**From:** [Luke Joseph](#)  
**To:** [Ferdinando Macri](#)  
**Cc:** [Jim Baldwin](#); [Elise Mangion](#)  
**Subject:** HPE CM: RE: Notice of Exhibition - SSD-17491477 - Lang Walker AO Medical Research Building - Macarthur - Council  
**Date:** Friday, 28 January 2022 10:16:17 AM  
**Attachments:** [image002.png](#)  
**Importance:** High

Council is supportive of this application, and considers the proposed development a welcome investment into the planned health and innovation precinct of the Campbelltown City Centre.

Figure 4: Original loading bay location. Source: BVN

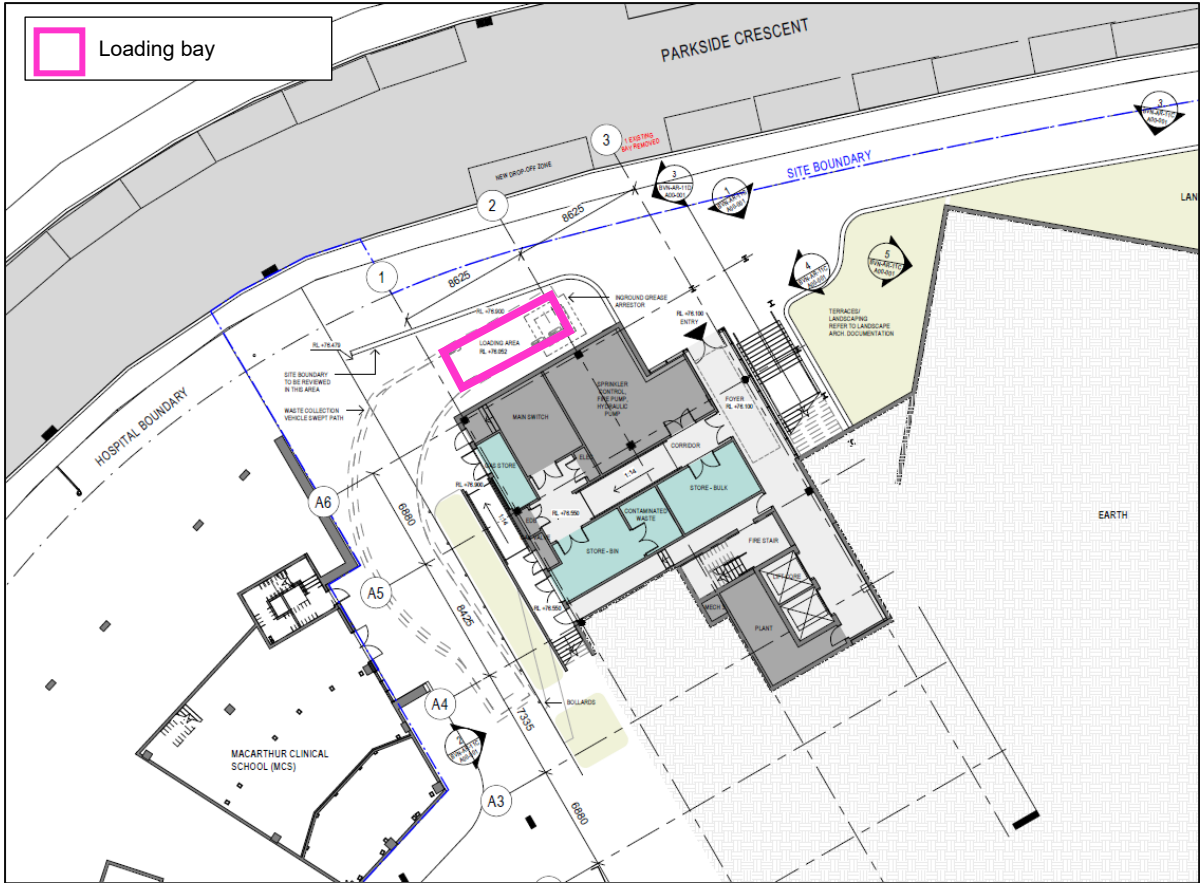
2. Similarly to the above point, Council is of the view that the proposed loading area facing Parkside Crescent would not be the best location for loading from an aesthetic perspective. Council would appreciate if the loading area could be relocated so that it would not be visible from Parkside Crescent. The opportunity for the loading bay to be accessed from within the hospital site should be pursued, as this is a "back-of-house" activity that should not be located between the building and the street.

3. From a traffic management perspective, additional driveway access from Parkside Crescent should be avoided, as this would result in reduced on-street car parking, and would negatively impact on the safety of all road users. As stated above, the opportunity for the loading bay to be accessed from within the hospital site should be pursued.
